# City of Albuquerque Stormwater Construction Site Inspection Report

ESC File No.	K09E051	Project Name:	Titan (Spec) 150K		
NPDES Id. No.	NMR1004R6	Location:	Daytona and Bluewater Rd		
8/2/2023	Owner	Contractor			
Operator	Westpoint 40, LLC	Wilger Construction			
Contact name & title	Brian Patterson	Tim Lindgren			
e-mail	<a href="mailto:bpatterson@titan-development.com">bpatterson@titan-development.com</a>	<a href="mailto:tlindgren@wilger.com">tlindgren@wilger.com</a>			
Contact Phone #	505-998-0163	505-239-0246			
COA Inspector	Chancellor English	Start/End Time:	11:30am		
Construction Phase:	Paving, landscaping, interior				
Type of Inspection:	Regular	Storm Event	Post Storm Event >0.25"	311/Complaint	Follow Up
Weather at time of inspection?	Clear		Temperature: ~	95	
Estimated date of last storm 0.25" or greater	5/22/2023

SEDIMENTATION/SILT FENCE WITH WIRE SUPPORT (SF)

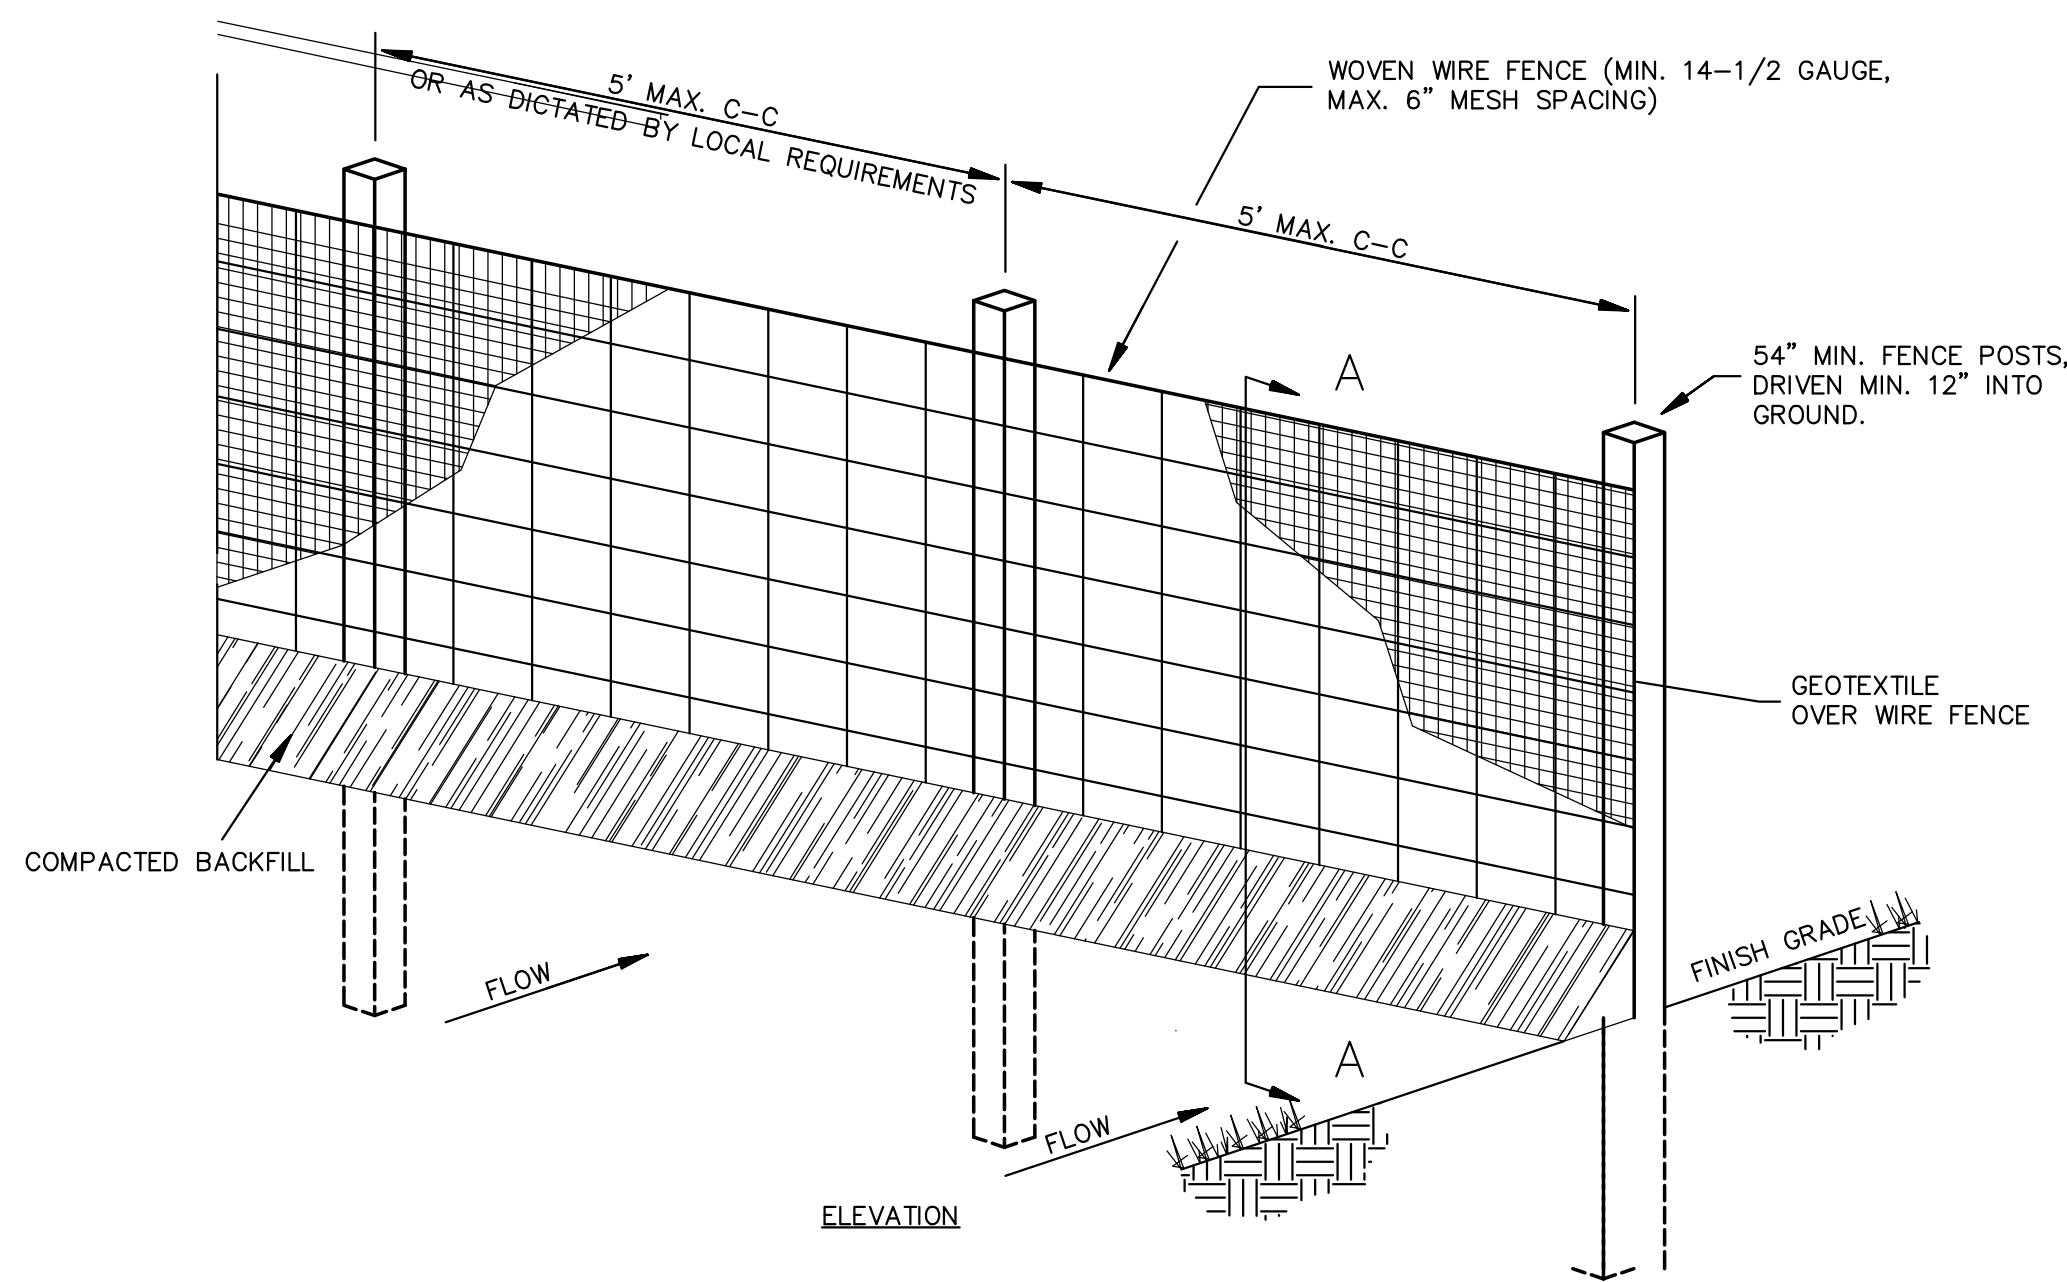
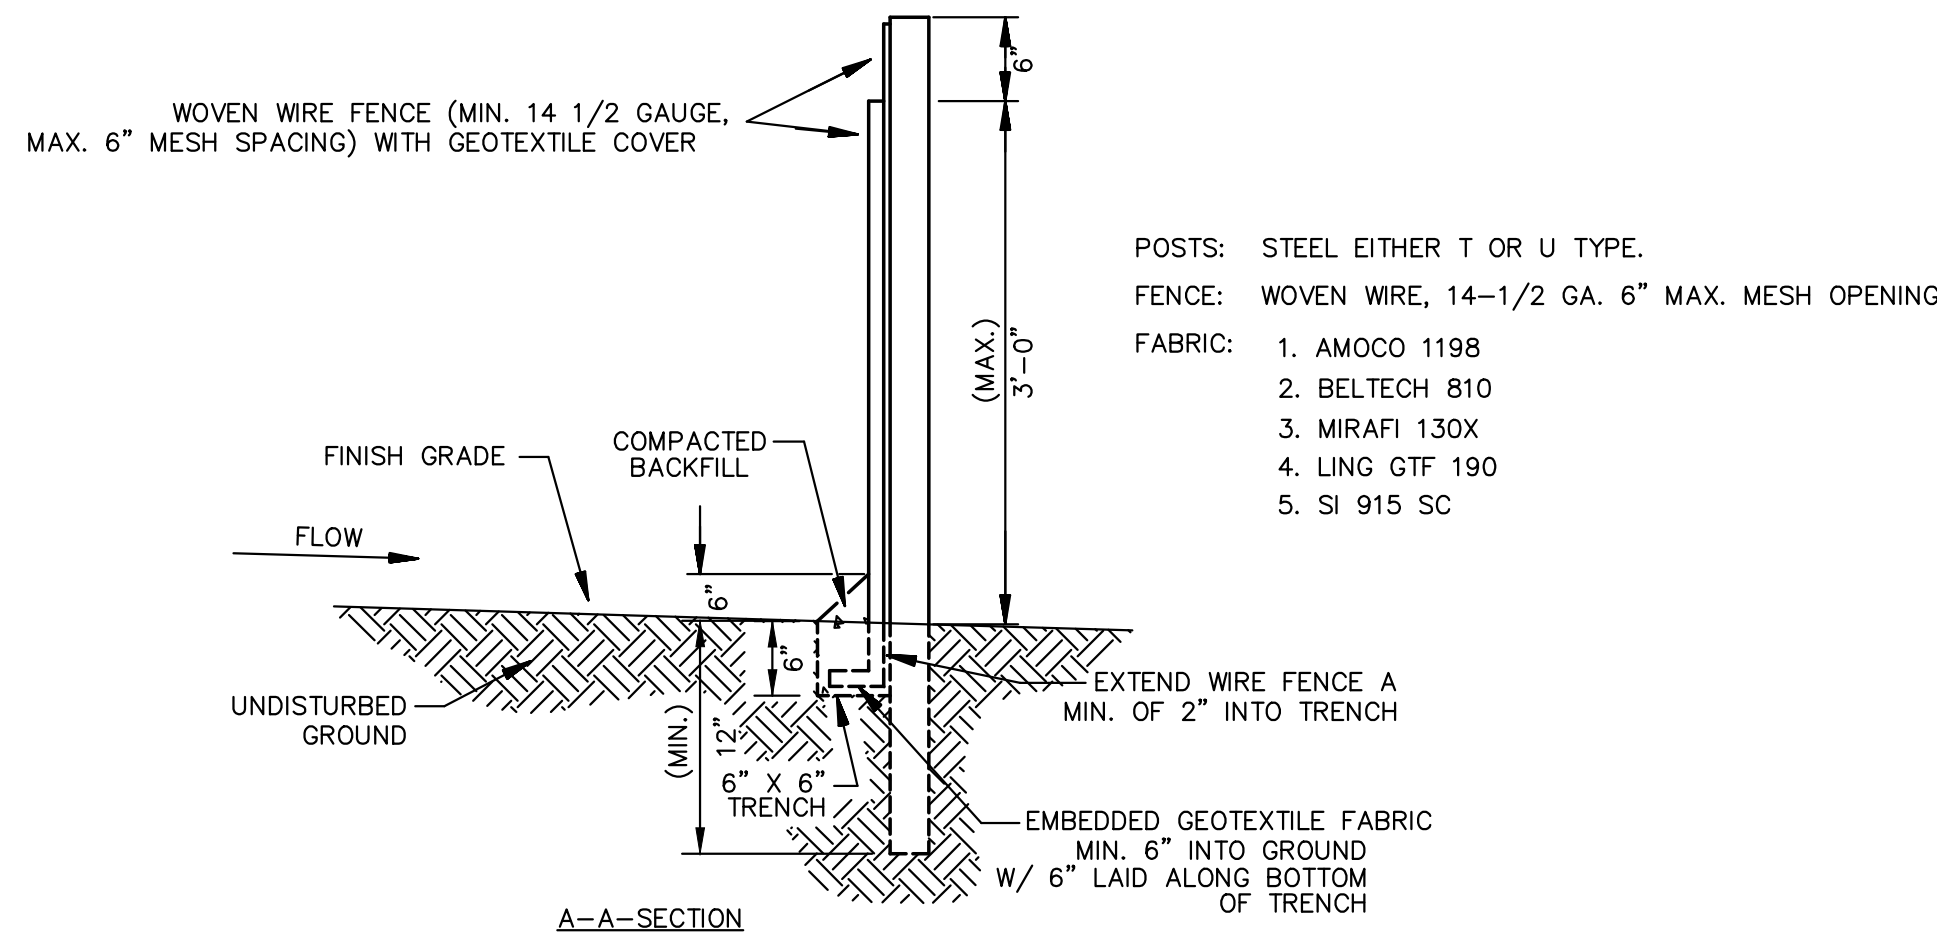
Item Number	Deficiency/ Corrective Action			
1	BMPs in need of repair. The silt fence along Daytona Road needs to be re-staked. Required mitigation: Ensure all stormwater controls are maintained and remain in effective operating condition during permit coverage and are protected from activities that would reduce their effectiveness as per CGP Part 2.1.4.			
2	The pond on the east side of the southern lot is partially stabilized. The southern lot and northern lot disturbances require stabilization that should be initiated if construction activities have permanently ceased or will be inactive for 14 or more calendar days. Required mitigation: Complete the pond and southern lot stabilization as required in CGP Part 2.2.14.			
3	A dirt ramp was found on the corner of Daytona Road and Bluewater Road. This ramp is located directly next to a stormwater curb inlet. The inlet protection needs repair. The City does not allow dirt ramps of any kind. Required mitigation: You must minimize track-out and use appropriate stabilization techniques at all points that exit onto paved roads, per CGP Part 2.2.4. You must protect storm inlets per CGP Part 2.2.10.

Notes:	Tim has SWPPP inside building
Previous inspection found out-of-date SWPPP and missing inspection reports (some issues with SWPPP were resolved), BMP maintenance/repair, and NOI posting. The silt fence on the west side of Daytona has been dmaged by wind and/or vehicles twice.
